PLANNING CONSULTATION RESPONSE

Application No	2026/0102
Proposal	Erection of front and side boundary wall 1m to 1.5m in height (Retrospective).
Address	11 Hardwick Grove, Dodworth, Barnsley, S75 3SS
Date of Consultation Reply	16 th March 2026
Consultee	Highways DC

Drawing Title **SITE PLANS**

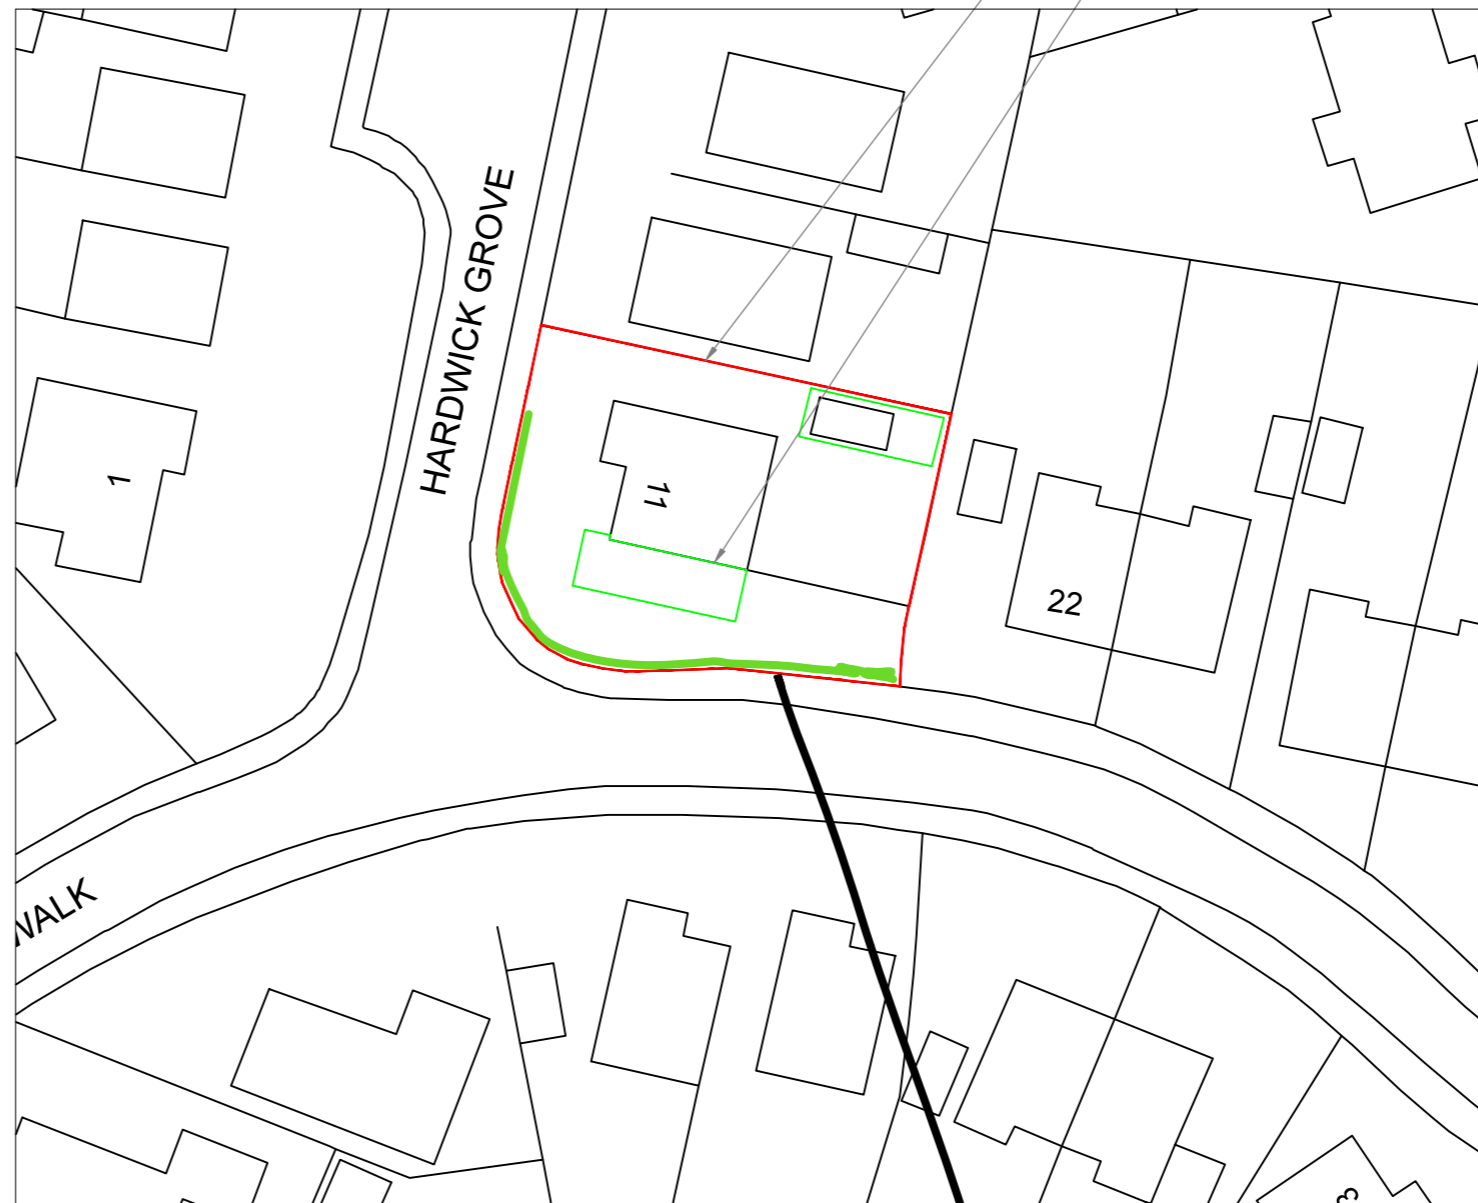
There appear to be discrepancies between the various submitted plans with regard to the position of the wall in relation to the existing driveway. As such, it is unclear whether the required 2m x 2m pedestrian visibility splays are to be provided at the site access. For clarity, the applicant/agent should note that the vehicular access must provide pedestrian visibility splays of 2m x 2m to the back edge of the footway. Nothing shall be erected, retained, planted and/or allowed to grow at or above a height of 0.6m to the rear of the footway which would obstruct the visibility splays; the visibility splays are measured as per the diagram below:
